# CITY OF ALBUQUERQUE

October 20, 2015

**Re: Advanced Auto Parts  
6-Month Temporary Certificate of Occupancy- Transportation  
Development**  
Engineer's/Architect's Stamp dated 6-18-15 (K17-D110)  
Certification dated 10-13-15

SITE PLAN

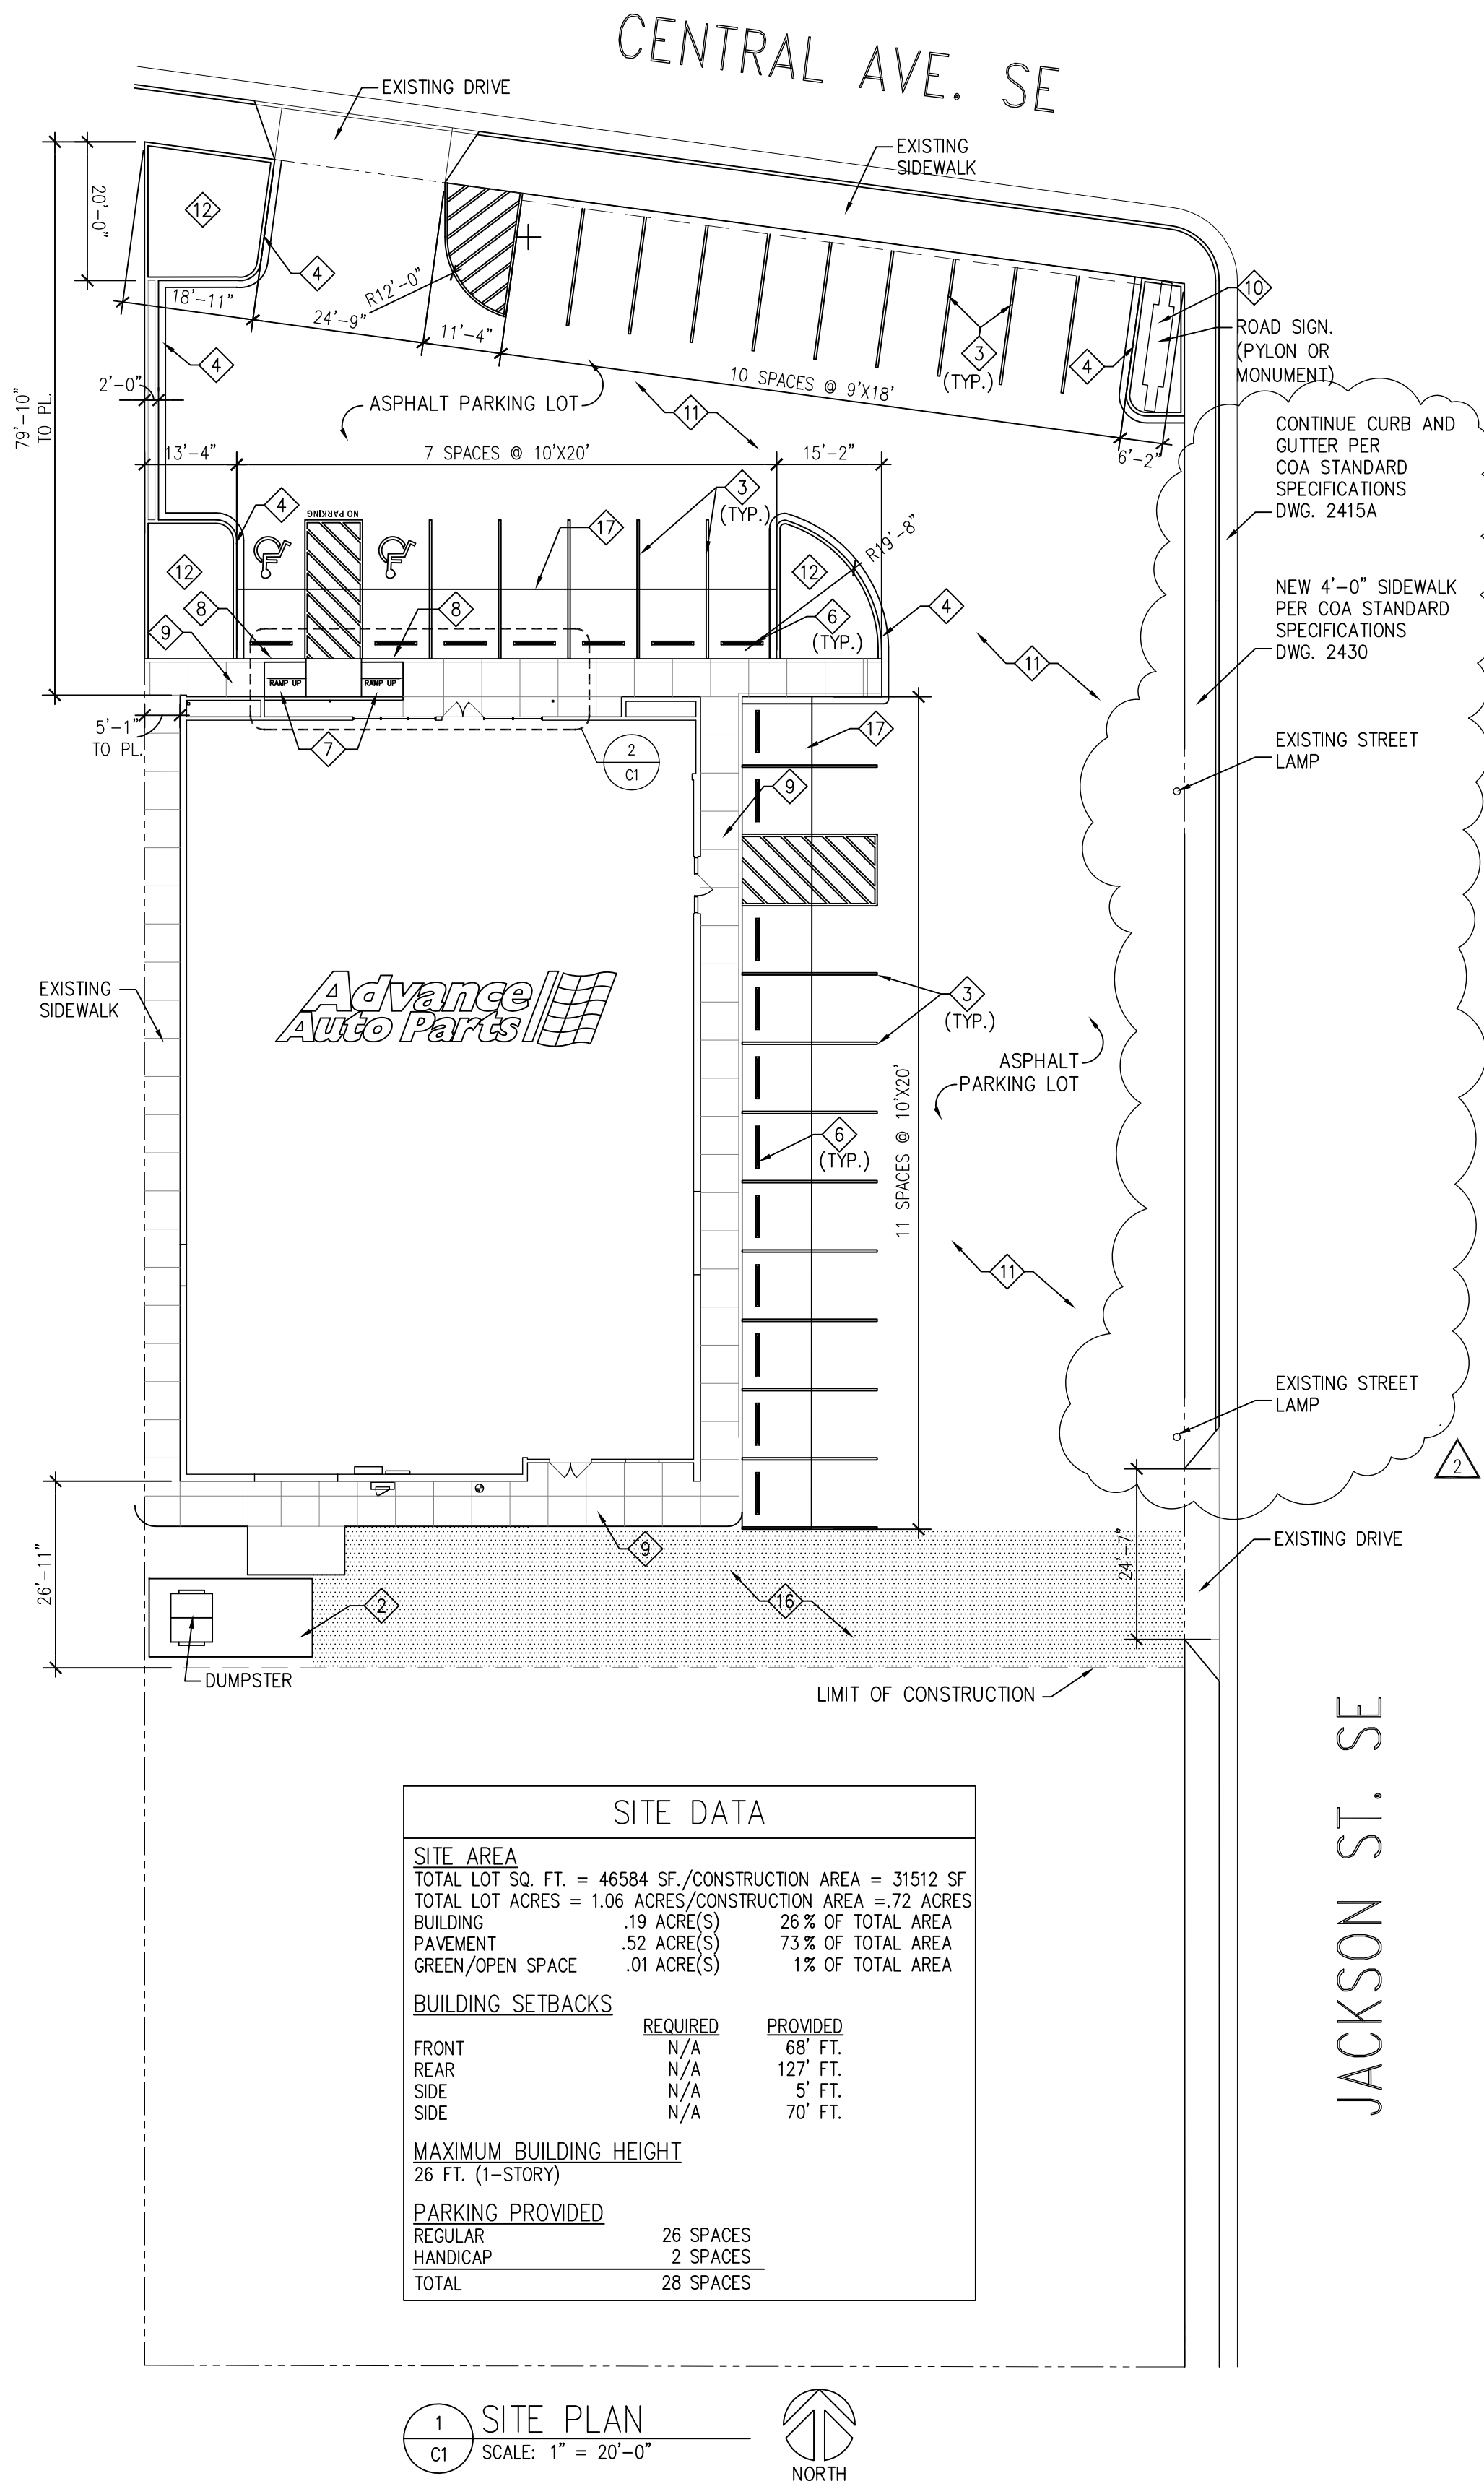
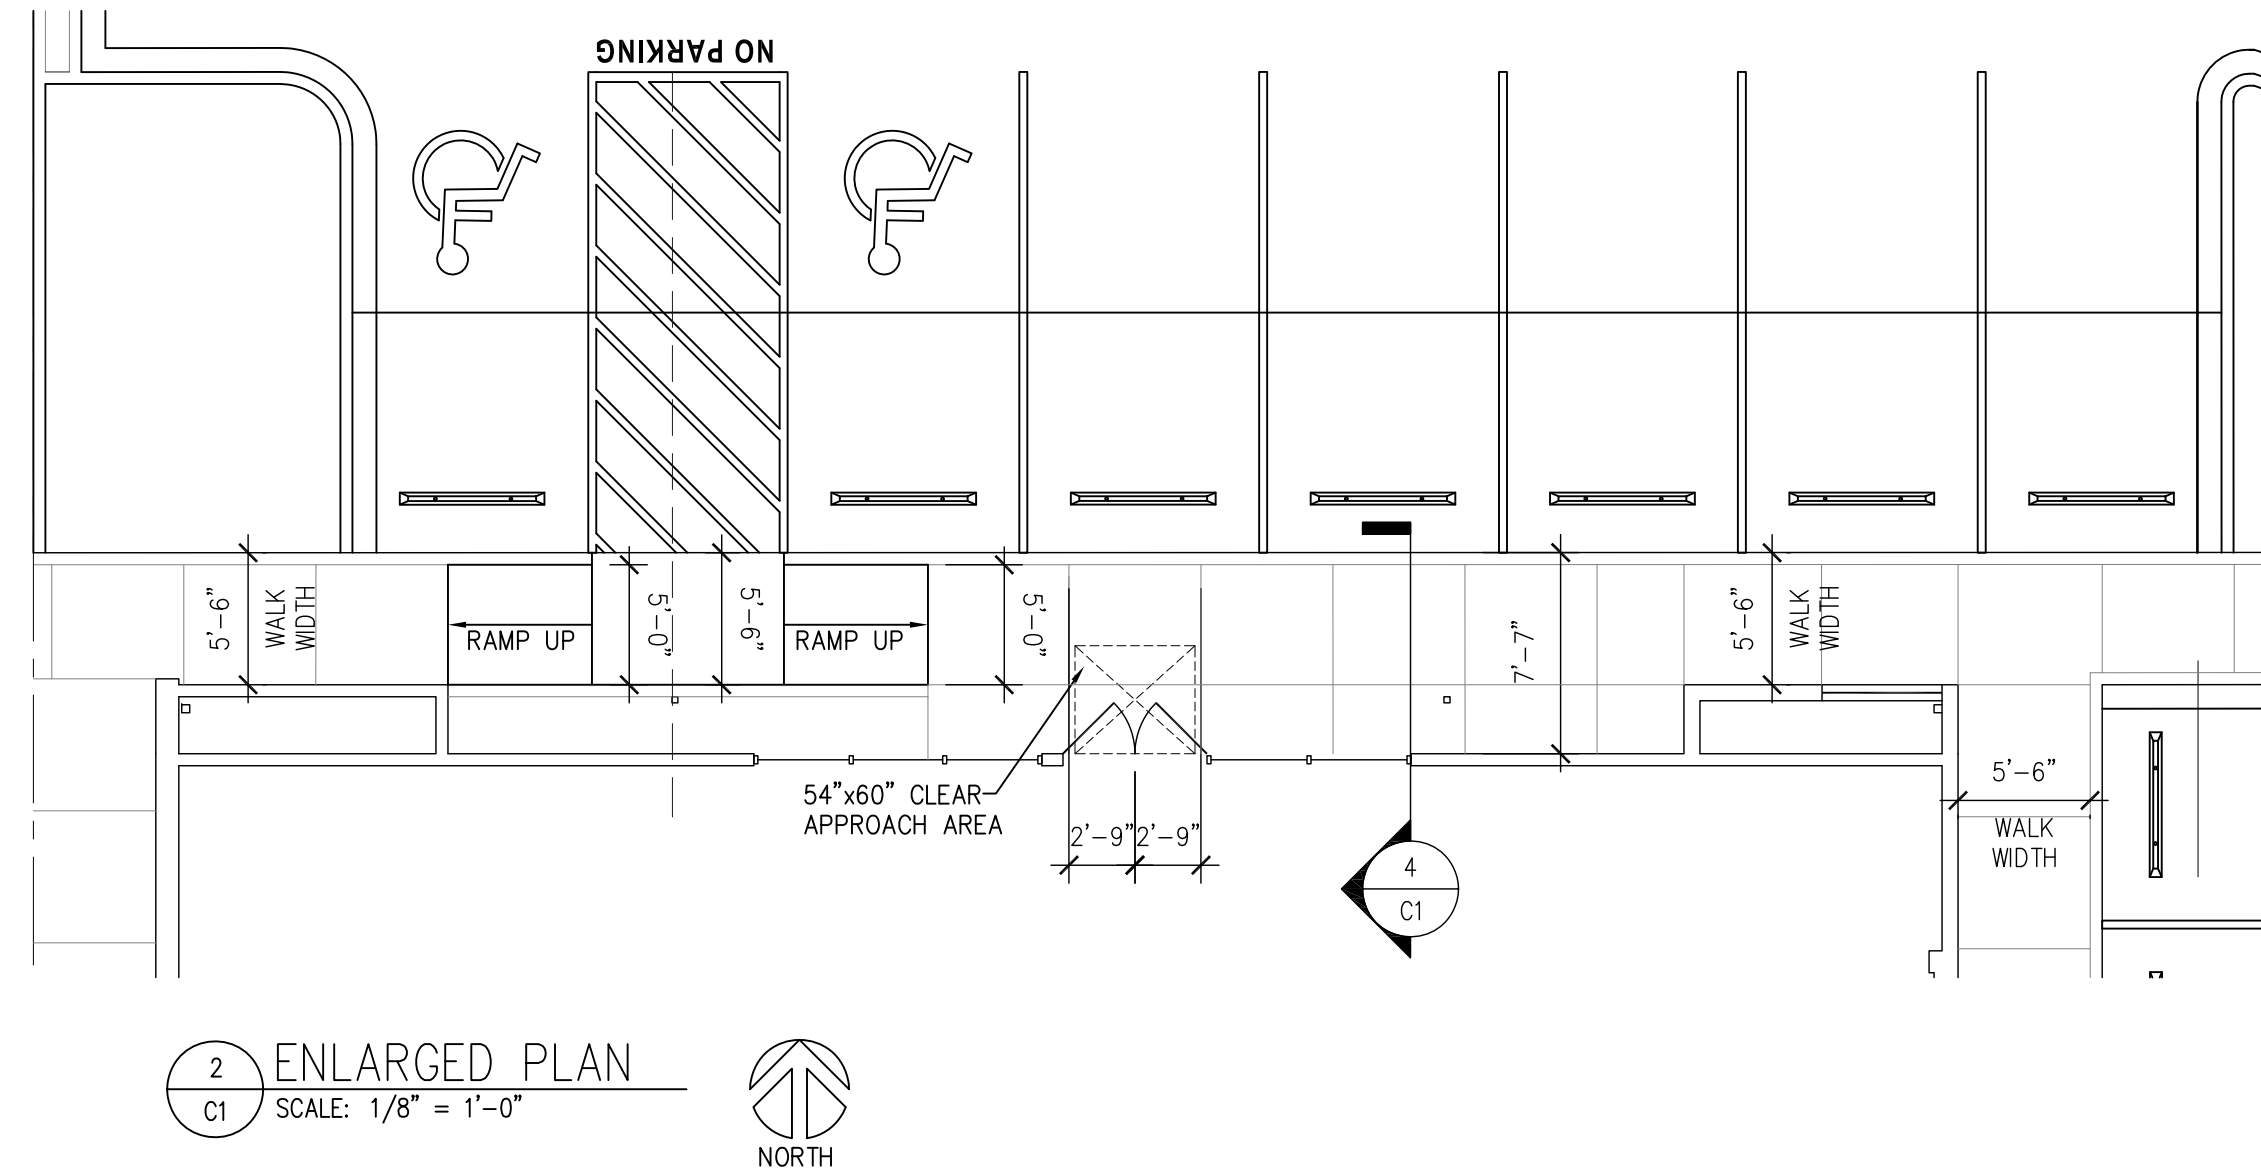
- Addition of 4 ft. sidewalk along eastern frontage per COA Standards, along with a bump out around existing power pole.
- Upon completion and submittal for Final CO, Certification date language must state that project is being certified in accordance to approved plan and it's stamp date.
